Date: 14th November 2022

**Sherringham Shoal & Dudgeon Offshore Wind Farm Extension Projects
APPLICATION REFERENCE No. EN010109**

**Application by Equinor New Energy Ltd for an Order Granting Development Consent
for the Sherringham & Dudgeon Offshore Wind Farm Extension Projects – Relevant
Representation by The East of England Ambulance Service NHS Trust (EEAST)
Pursuant to Section 56 of The Planning Act 2008**

EEAST has reviewed the DCO application documentation and raises a non-statutory **HOLDING OBJECTION** on the following basis:

Ref No.: 20.1027.Map1	Sheet: 1 of 4	Rev.: 0
--------------------------	------------------	------------

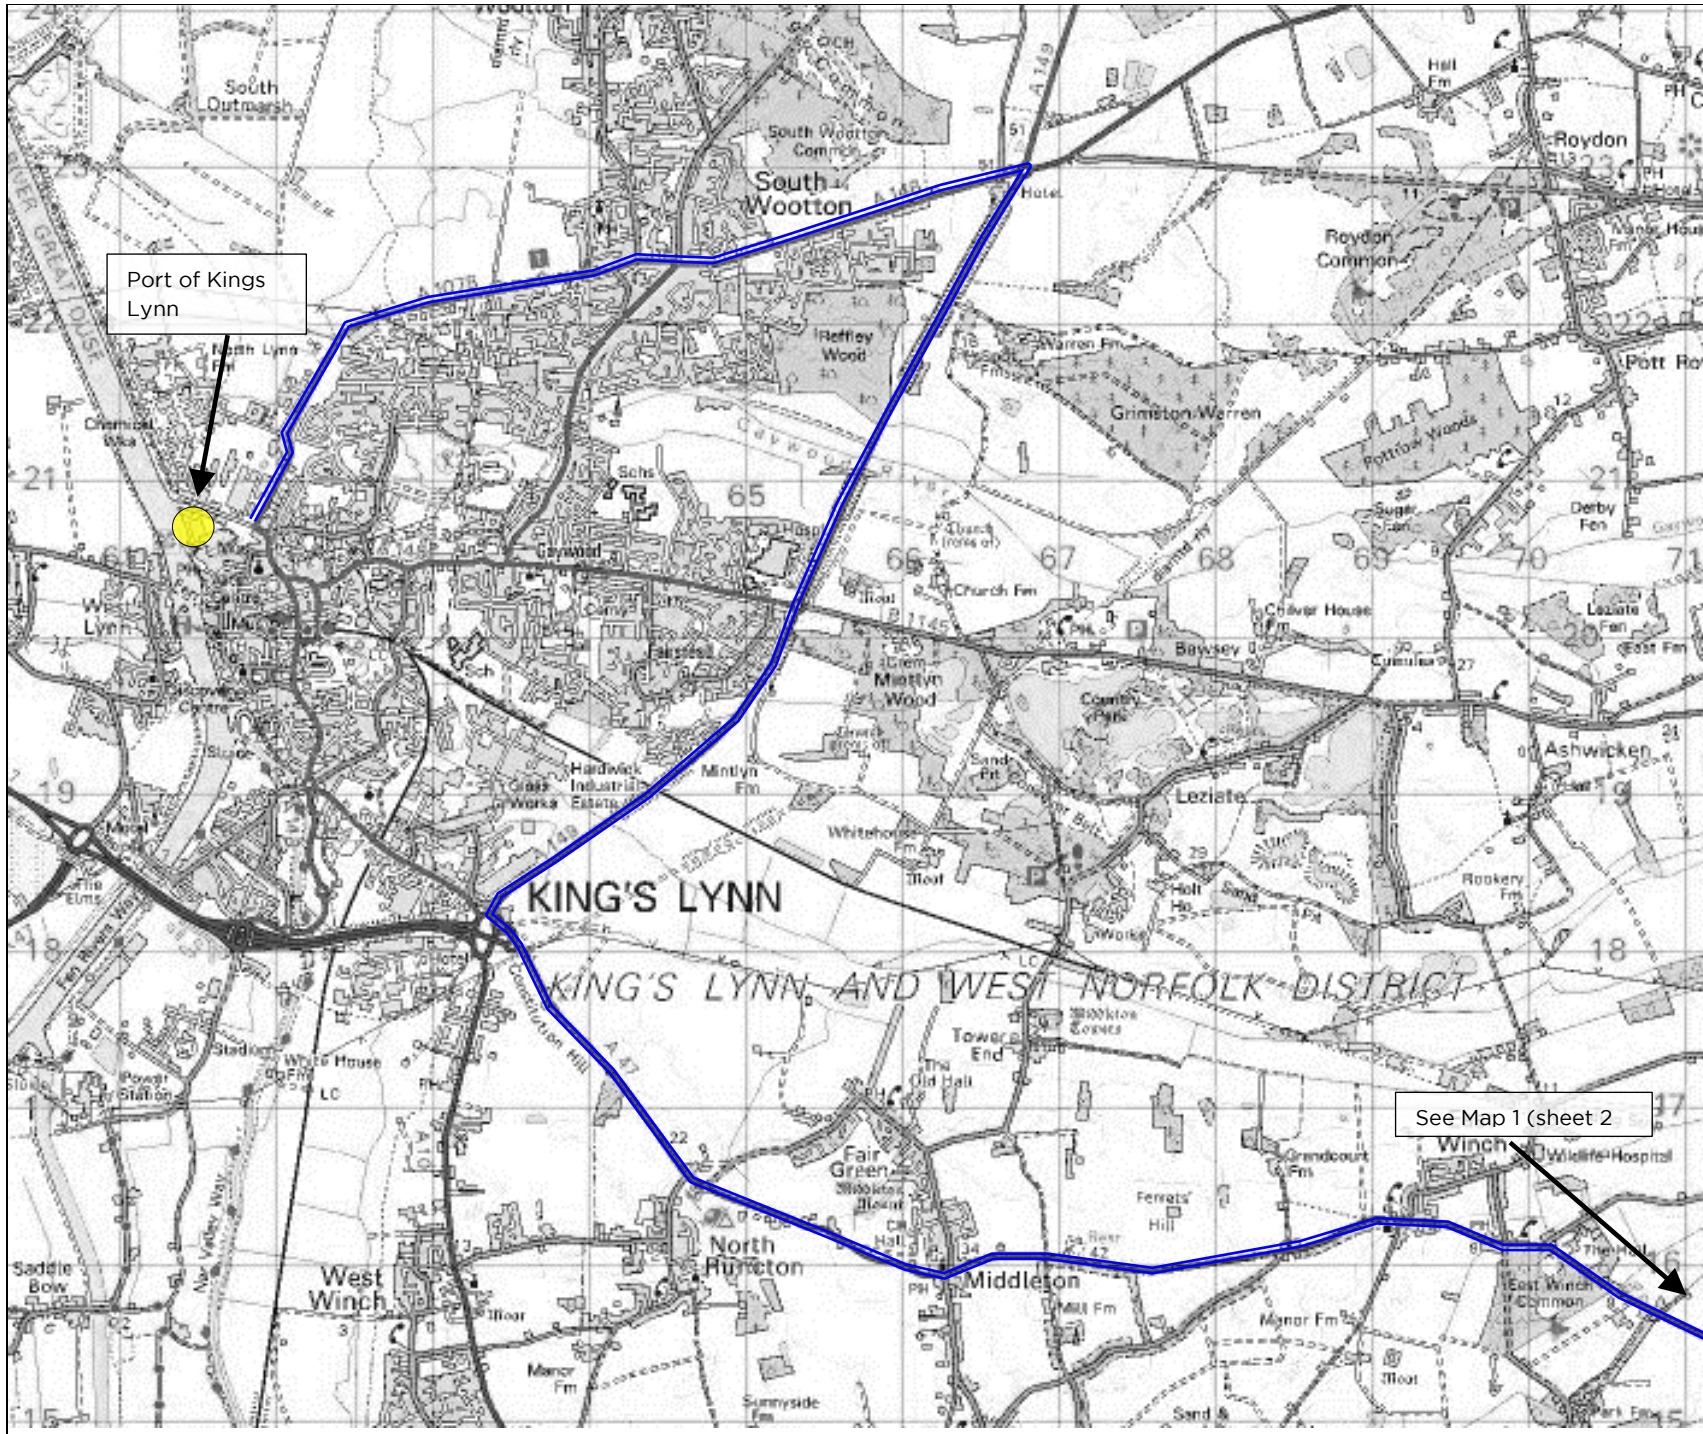
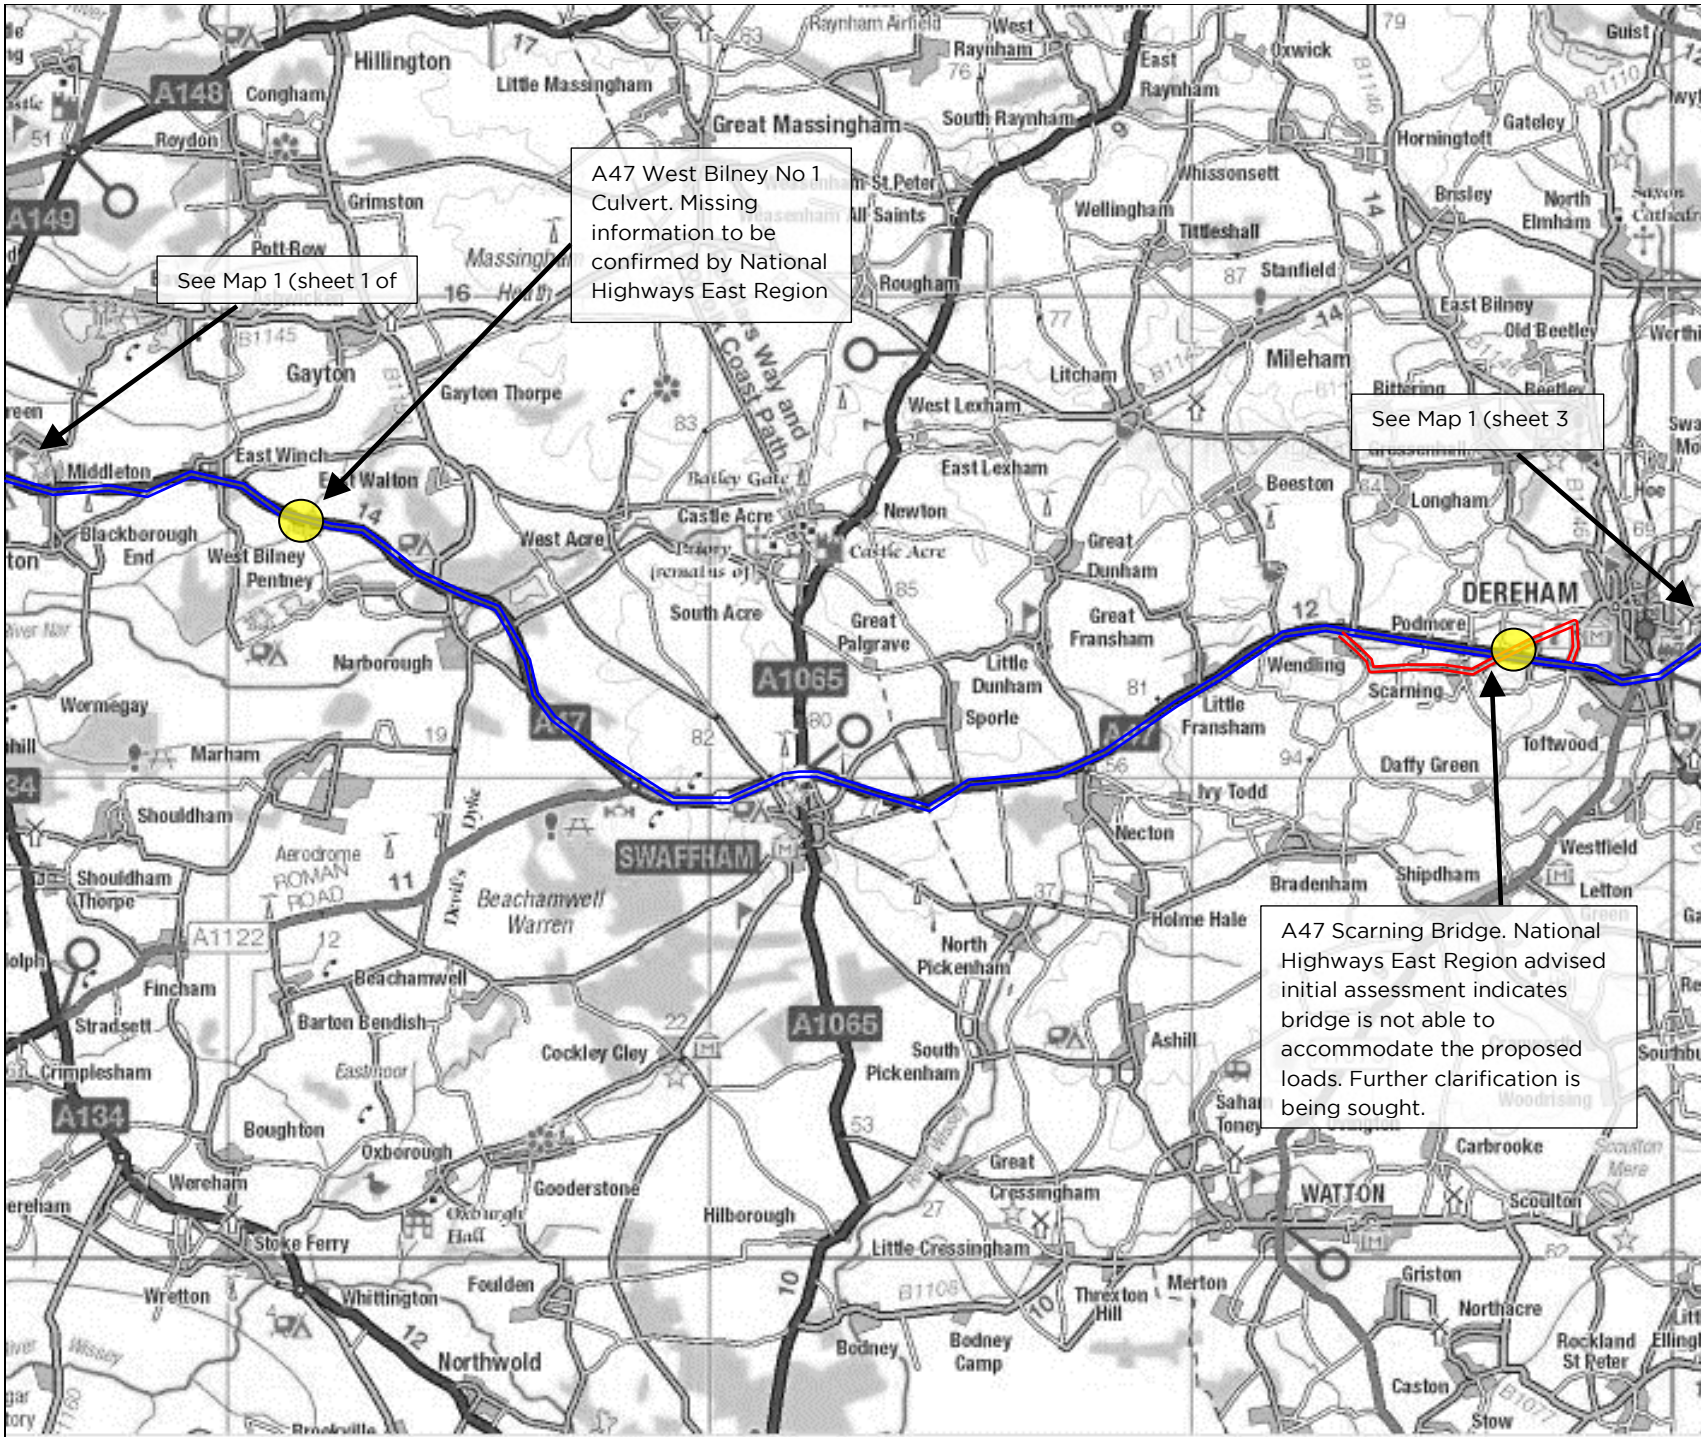
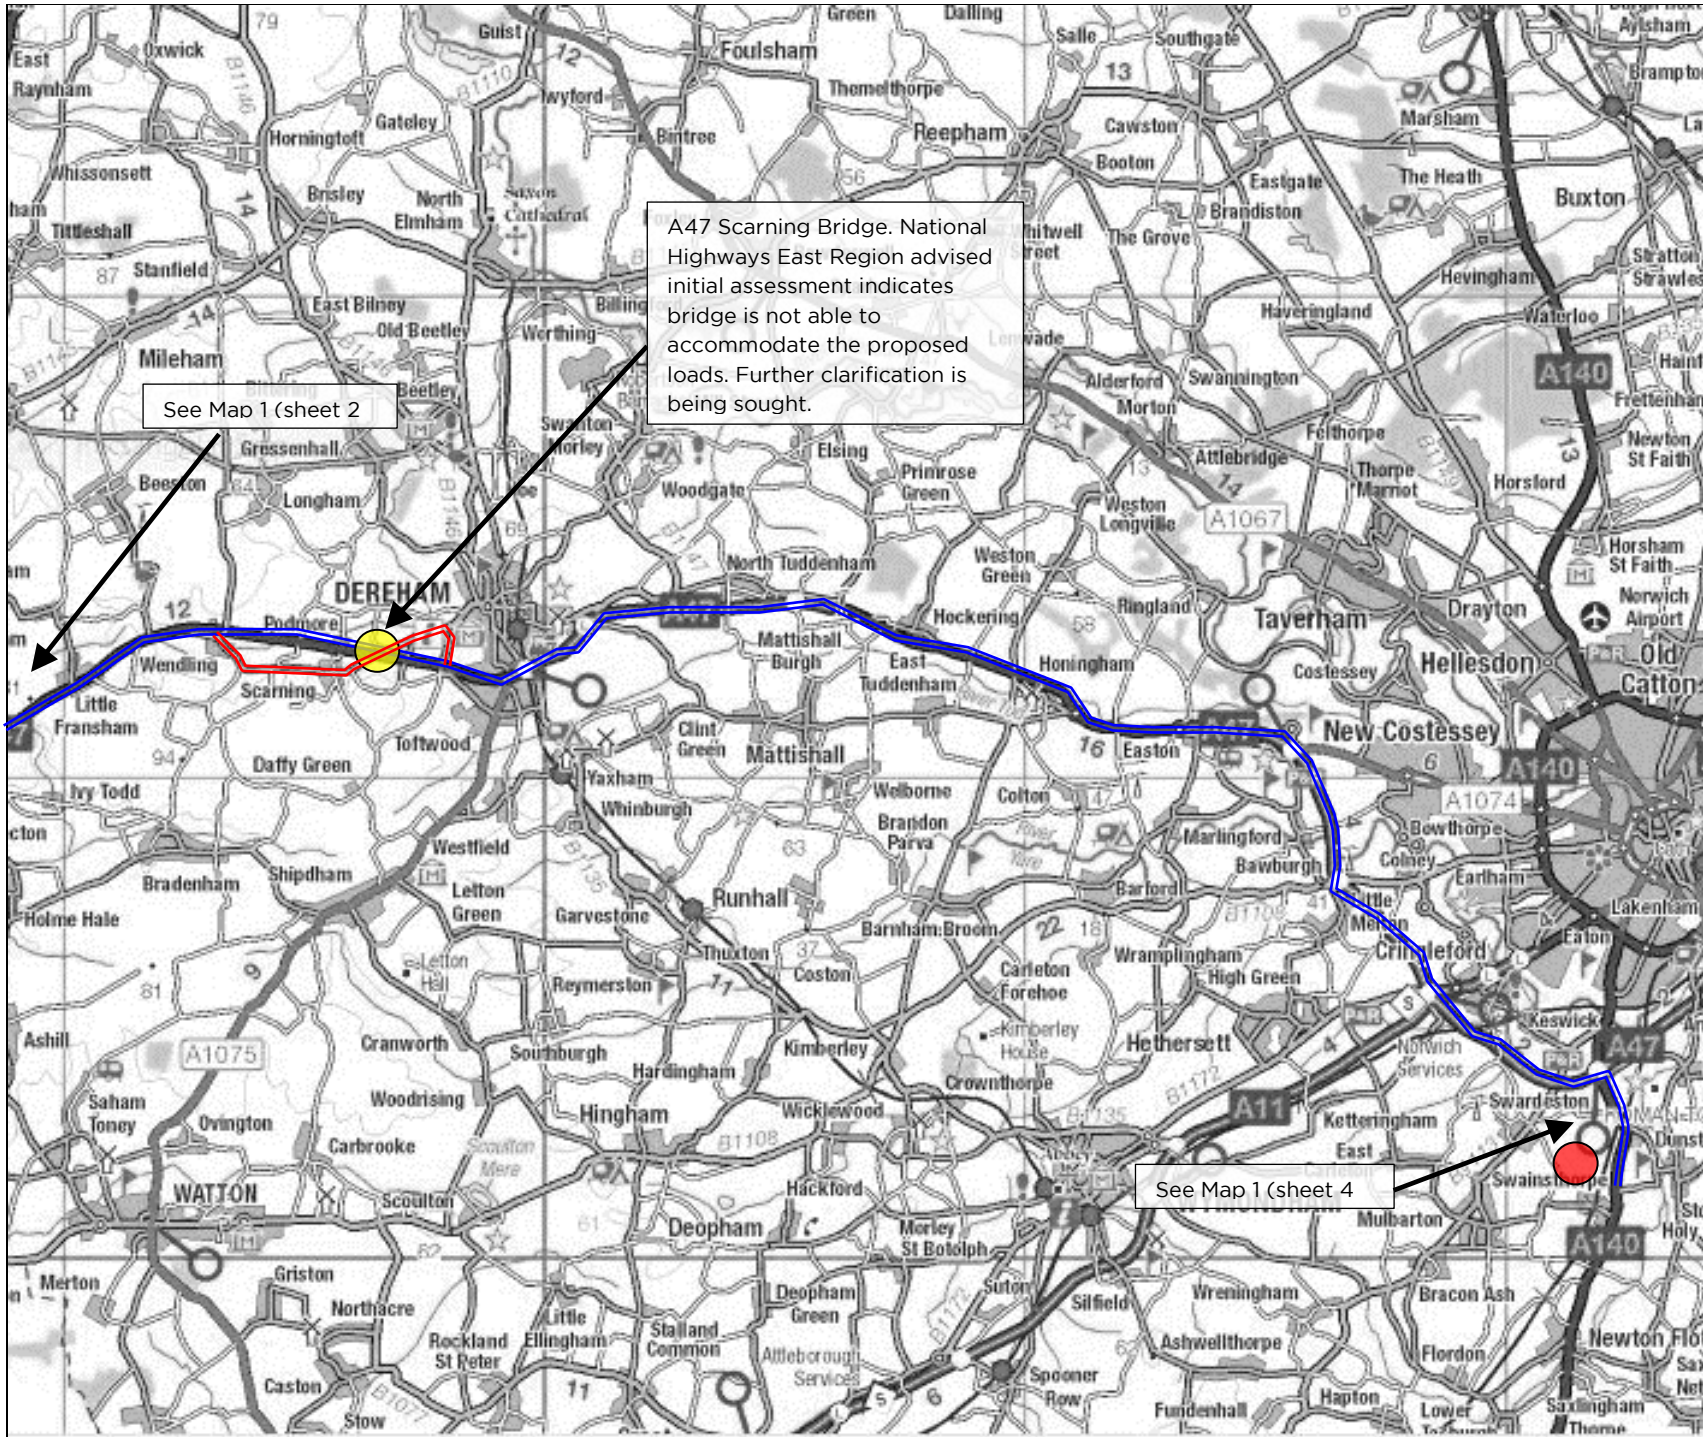
Whilst the scope of the Report is principally focused on 'route planning feasibility' from Kings Lynn Port to Norwich, which remains unresolved at present due to highway structure and land constraints, it is evident that ALL's are likely to be a key highway network impact requiring appropriate mitigation and management.

It is noted that the Transport Chapter of the ES does not seem to address the issue of ALL's, and information is therefore required on the forecasted number, type, route selection, timing and duration of these highway related impacts.
